**From:** Laura Gibbons  
**Sent:** 11 April 2019 12:59  
**To:** Planning.Responses  
**Cc:** Anita Gardner  
**Subject:** RE: Planning Consultation on LU/109/19/DOC

Engineers Comments Regarding Condition 3 and 4

**APPLICATION**                      **LU/109/19/DOC**

**Site Address:**                      Shell Eastfield Worthing Road Littlehampton BN17 6LE

Drawing No.
6239-20

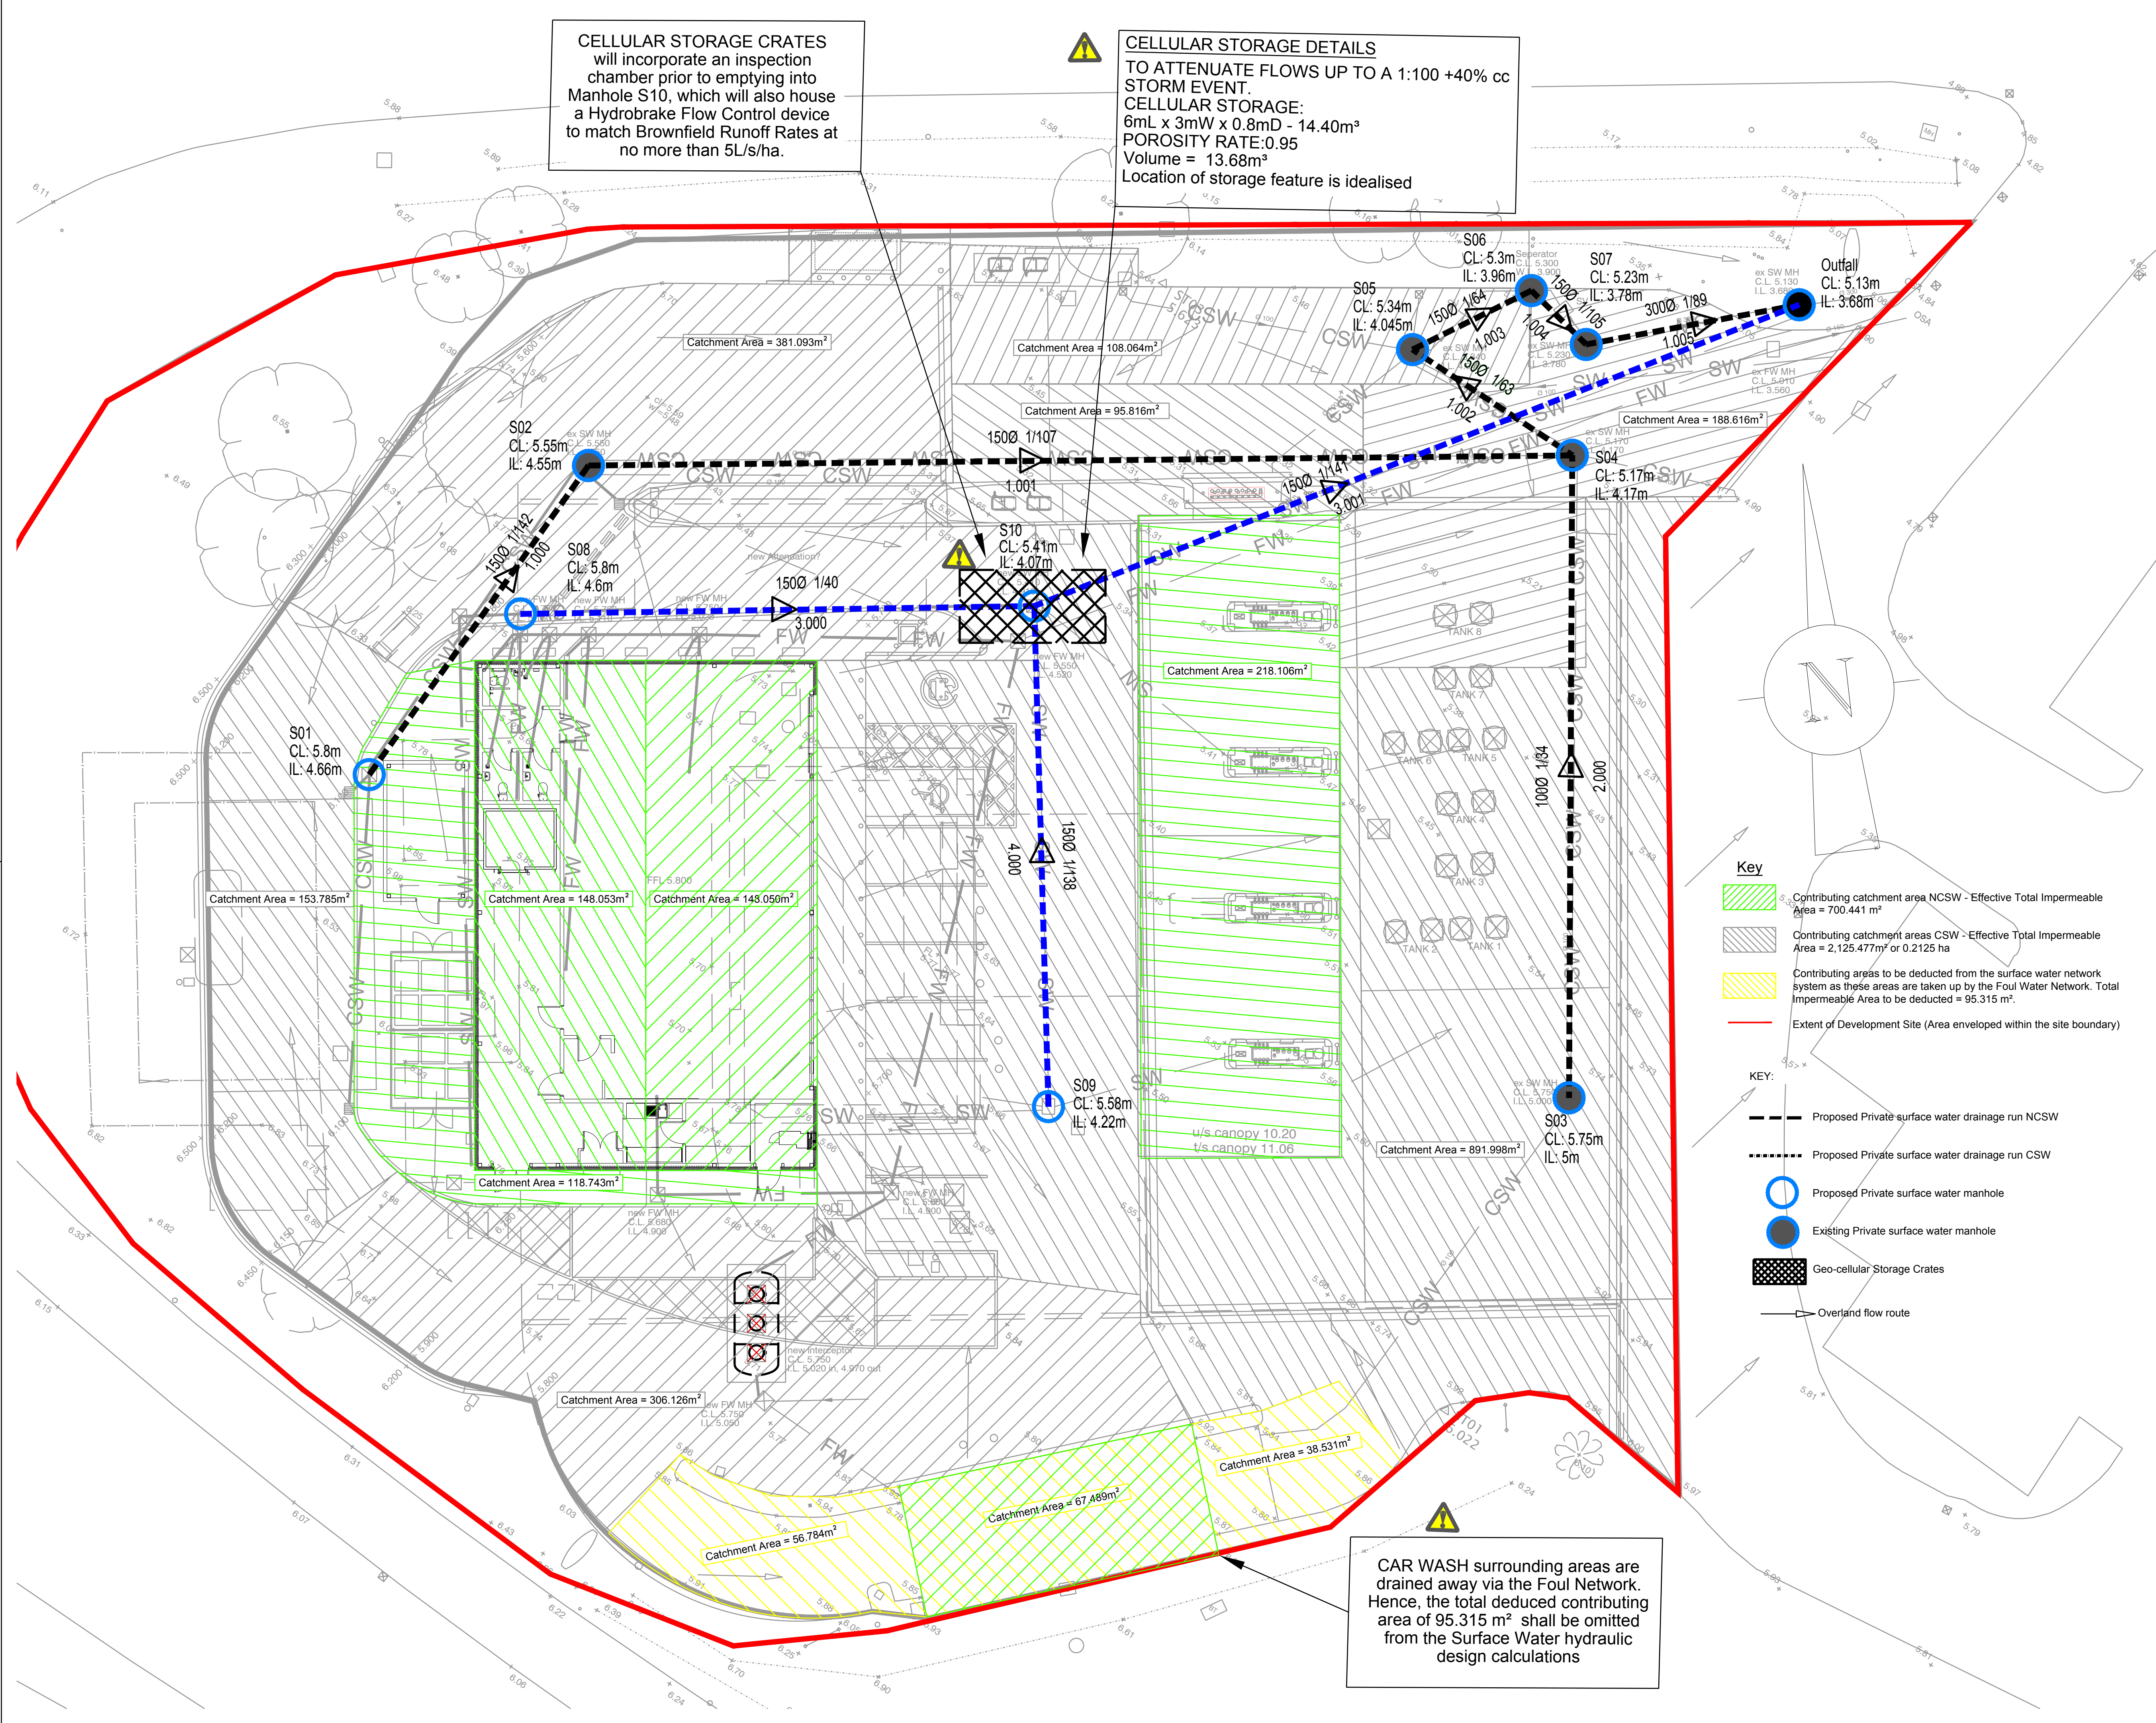
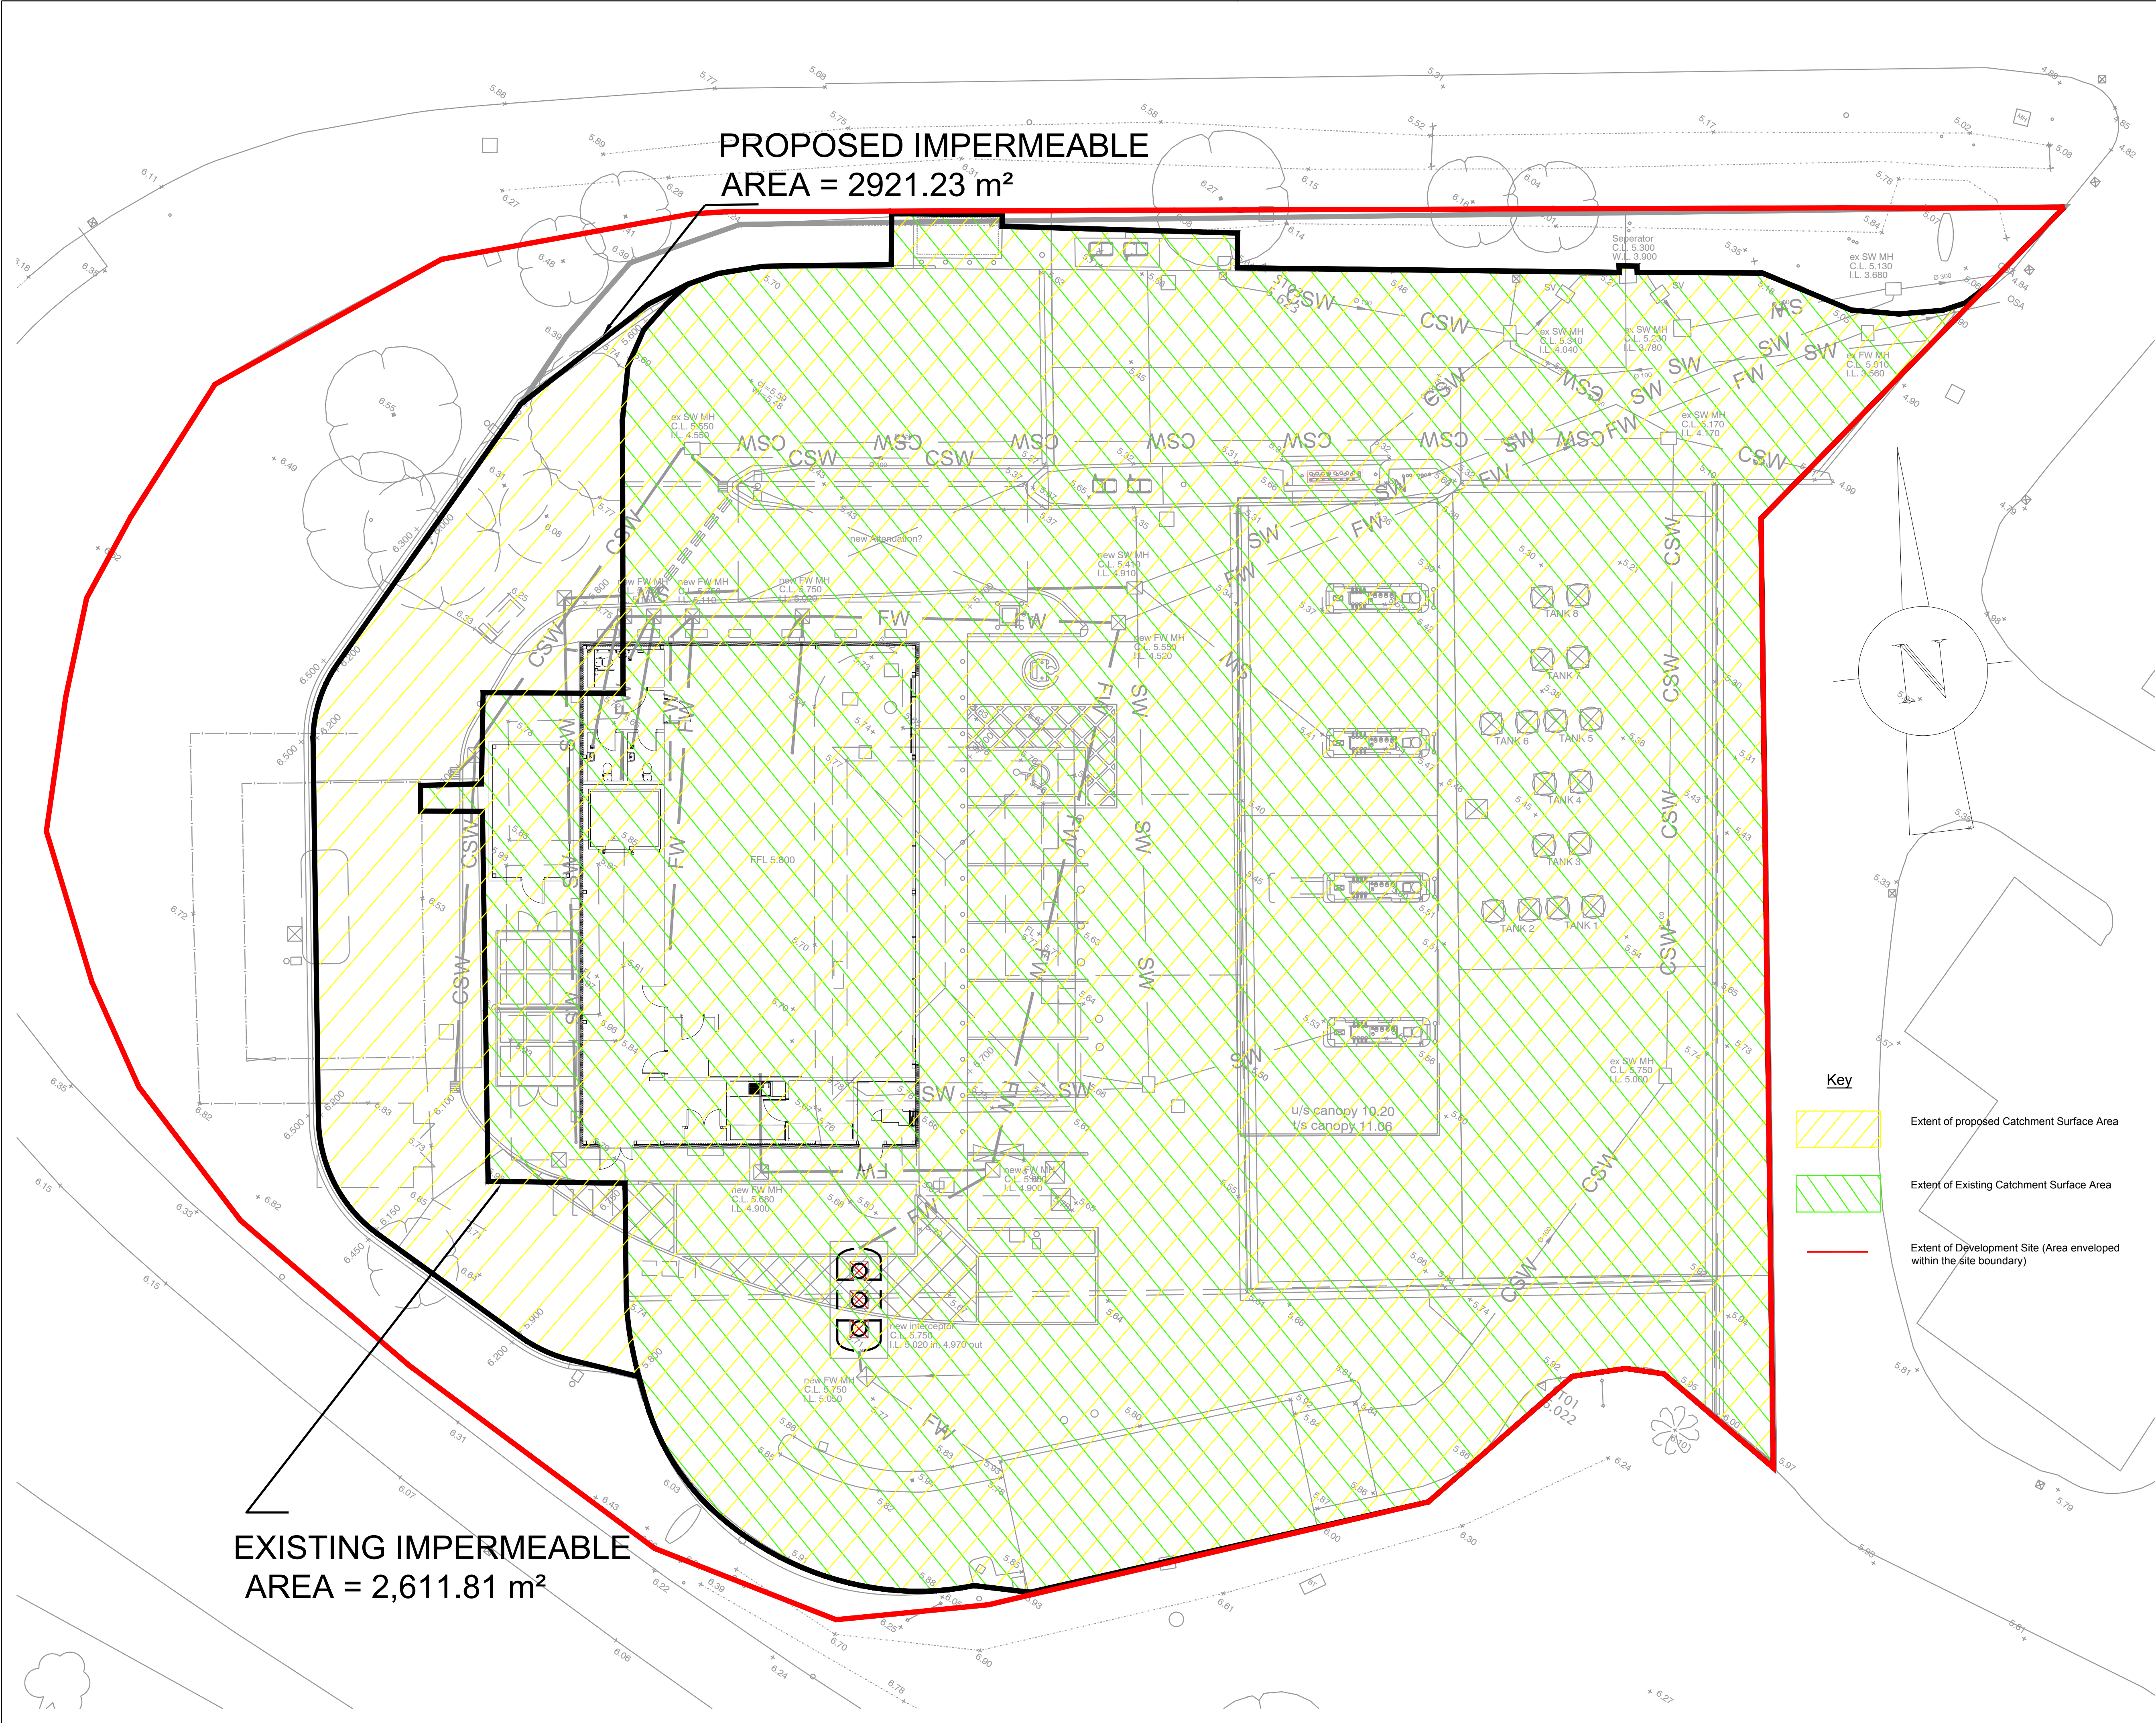
3. The layout plan provided is unclear in terms of differentiation of the two networks. Please revise line types etc.
4. Catchpit manholes should be provided upstream of attenuation tanks.

5. On the layout plan provided everything appears to be ending up discharging to the same location. Yet the text states that the non-contaminated surface water will be discharging to surface water sewer and the contaminated will be discharged to foul sewer. Please confirm and please provide clarity as to whether the proposals are to utilise an existing foul water connection.

Flow Control Device Chamber MH S14 (ADOPTABLE)

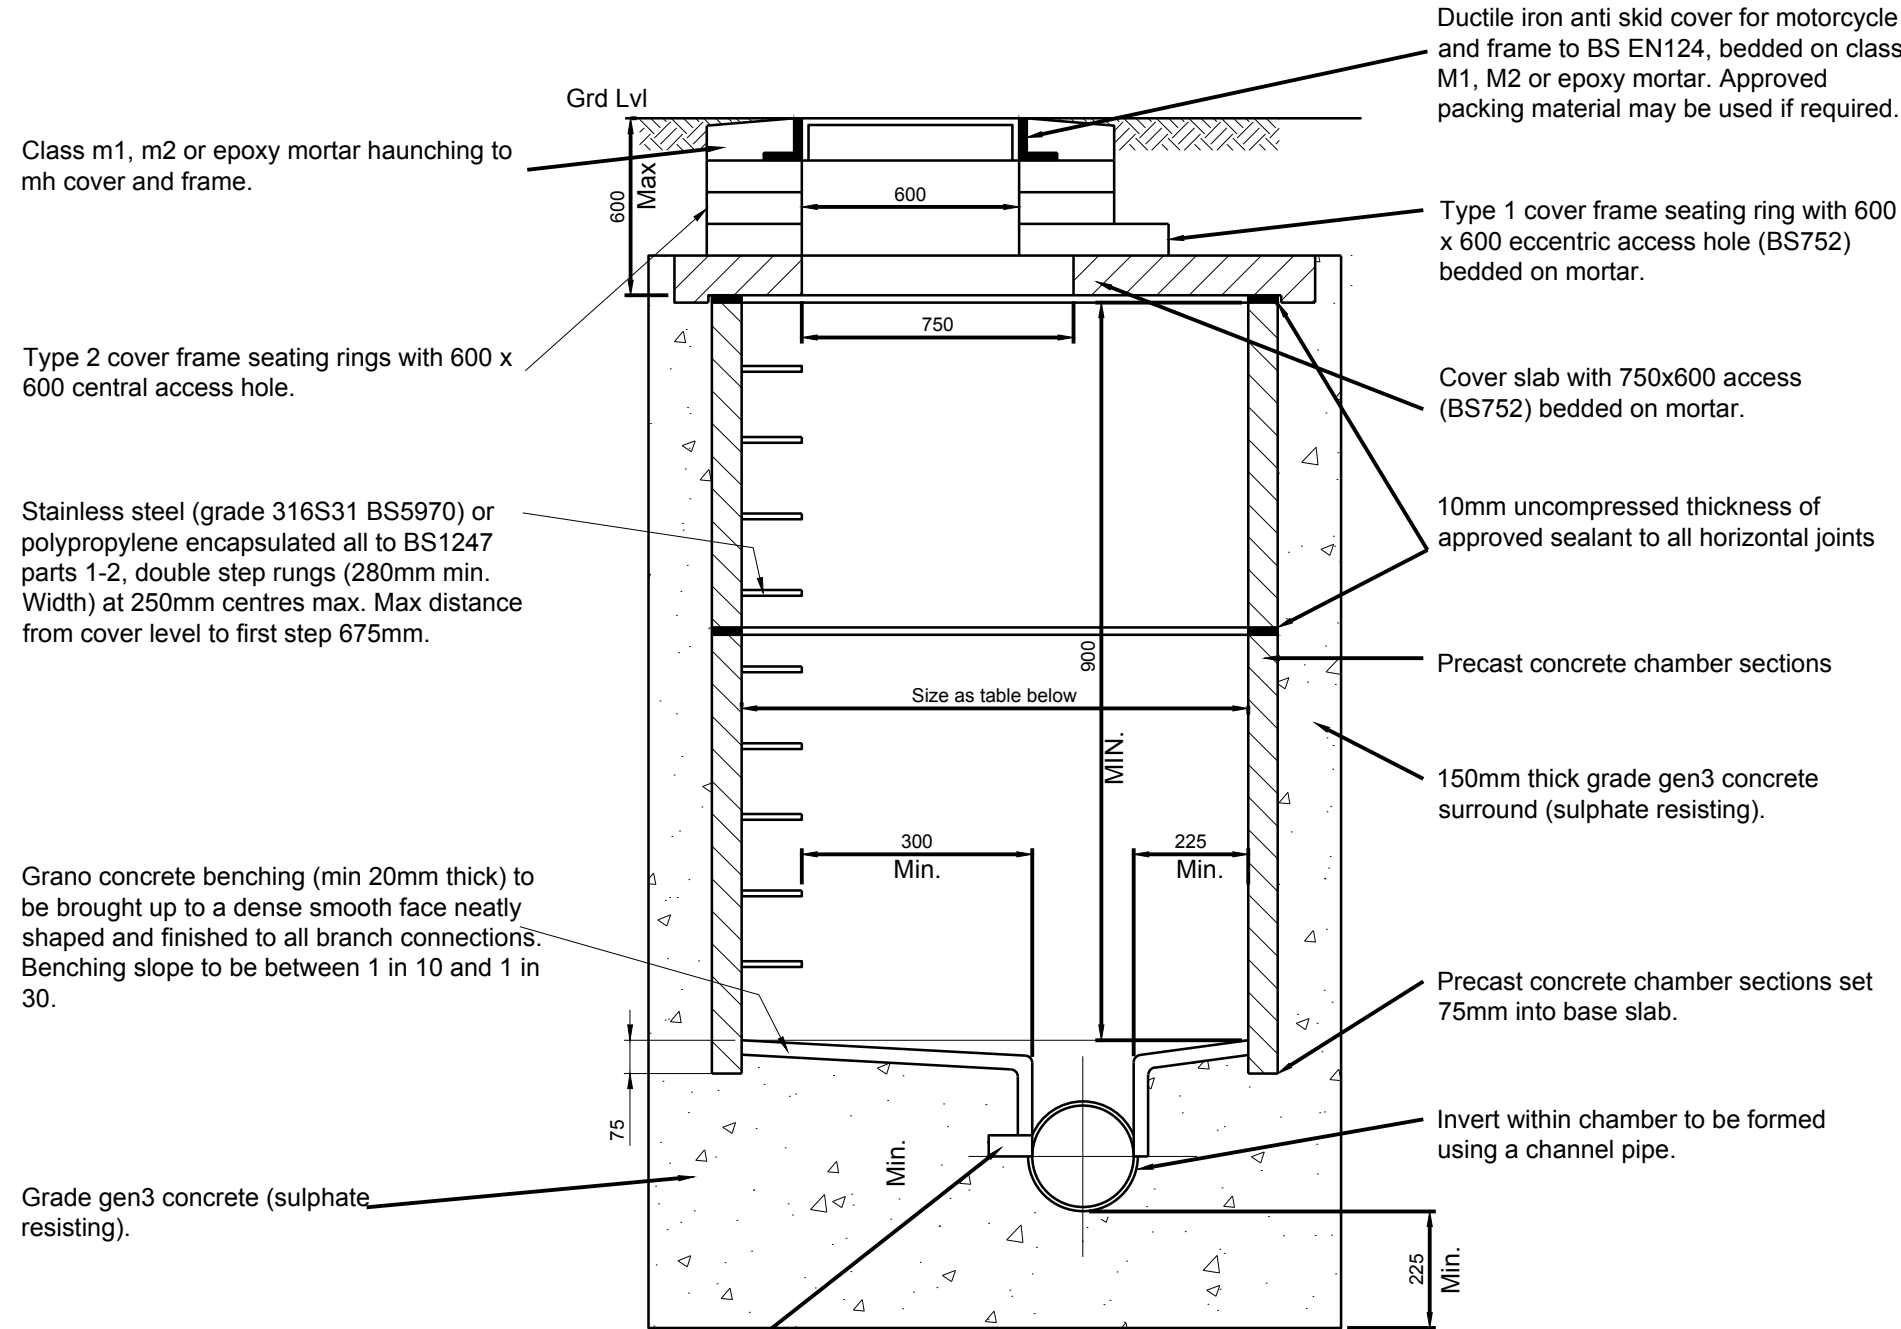
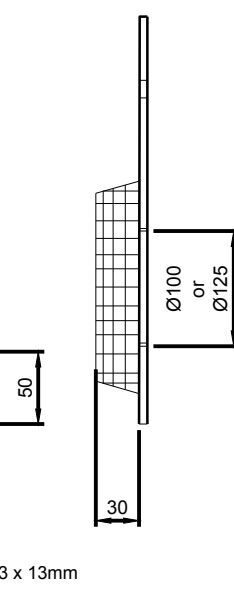
2. Proposed restriction rates from the non- contaminated surface water are too high. Evidence has been submitted which indicate QBar for the existing site is 2l/s yet proposals are for 5l/s. We accept flow restrictions down to 2l/s with appropriate measures provided (use of hydrobrake not orifice and min. 300mm sump) to ensure the risk of blockage is limited, EA guidance of 5l/s is outdated. Please revise design to restrict to 2l/s.
